SUPER STAR CAR WASH - FALCON MARKETPLACE LOT 10
SITE DEVELOPMENT PLAN

Lighting Plan_V1.pdf Markup Summary

Subject: Group
Page Label: [3] 20473 DR2.0 PHOTOMETRICS PRE-Layout1
Author: Sophie Kiepe
Date: 4/7/2021 2:50:33 PM
Status:
Color: ■
Layer:
Space:

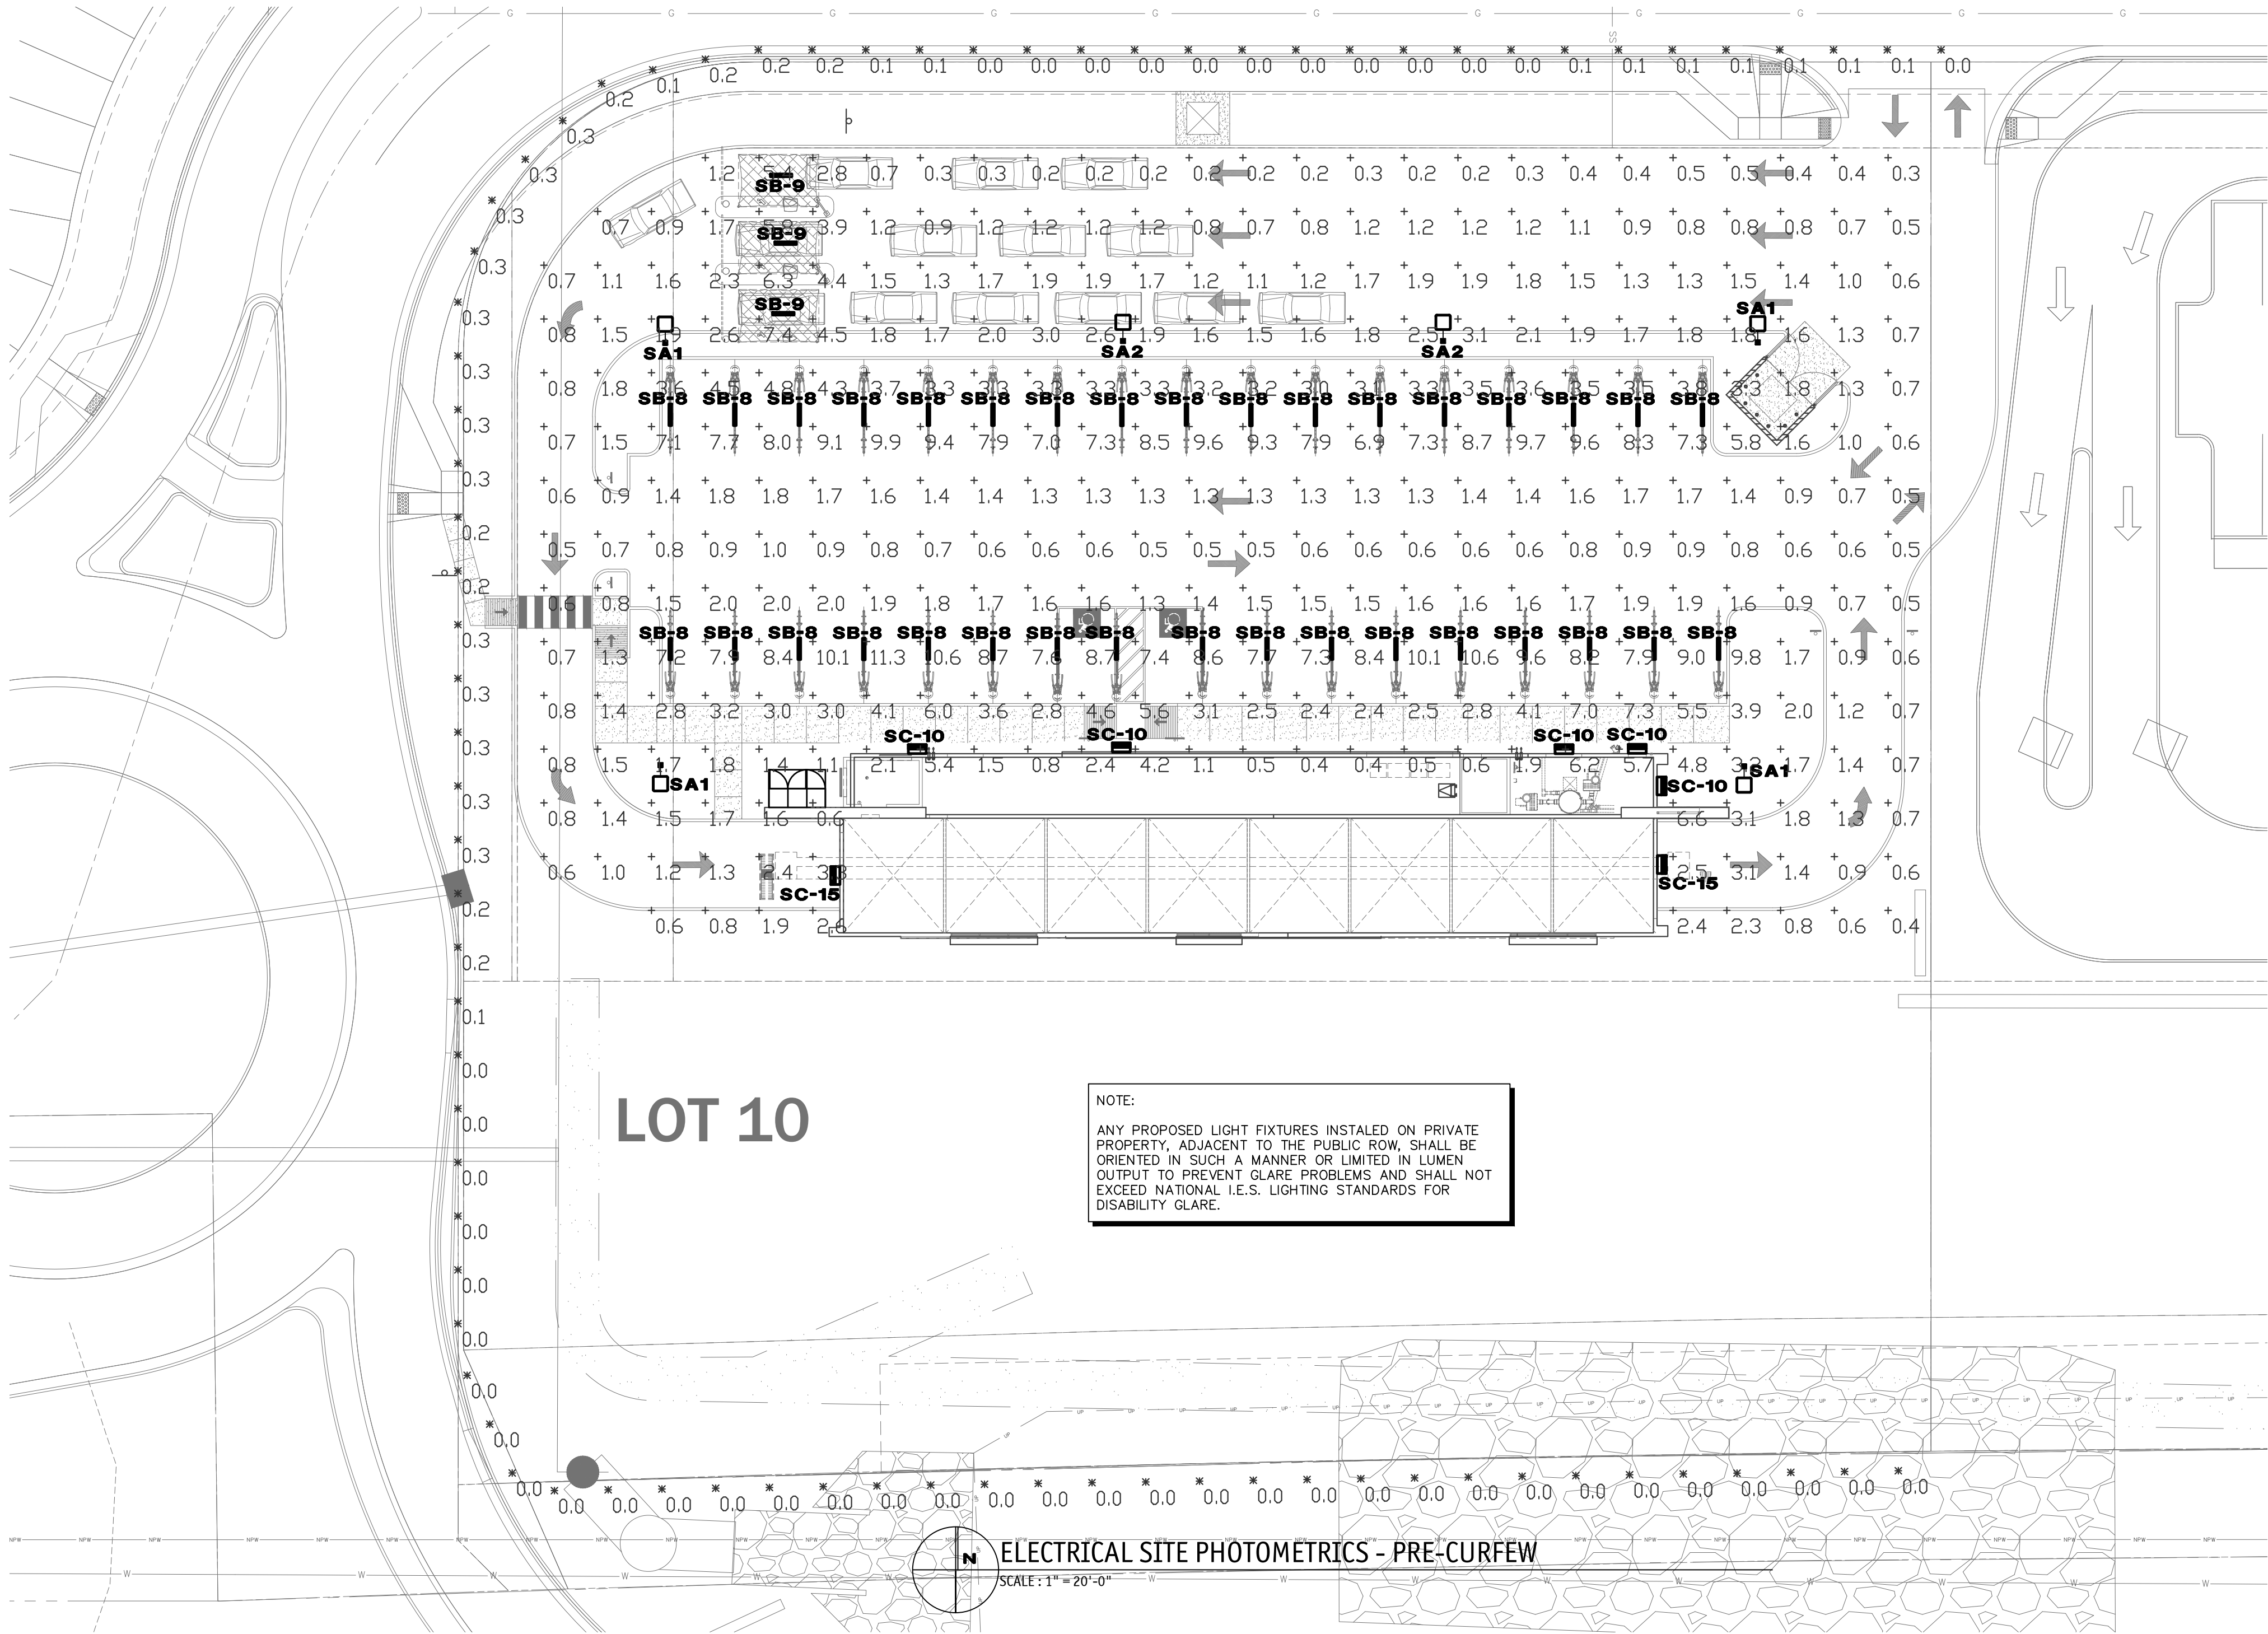
Footcandles exceed allowable limits at property boundaries along right of way. Per LDC Ch. 6 Lighting Standards:

- (d) **Maximum Levels.**
Maximum on-site lighting levels shall not exceed 10 foot candles, except for loading and unloading platforms where the maximum lighting level shall be 20 foot candles.
- (e) **Measurement at Property Boundaries.**
Light levels measured at the property line of the development site adjacent to residential property or public right of way shall not exceed 0.1 foot candles as a direct result of the on-site lighting. All light fixtures mounted within 15' of any residential property line of the site shall be classified as IES Type II or Type III, or fixture demonstrated to provide similar distribution patterns and shielding properties. Fixtures shall be fitted with "house side shield" reflectors on the sides facing the residential property line.

Please add title of this plan to the title block area - indicate pre/post curfew on each title block area.
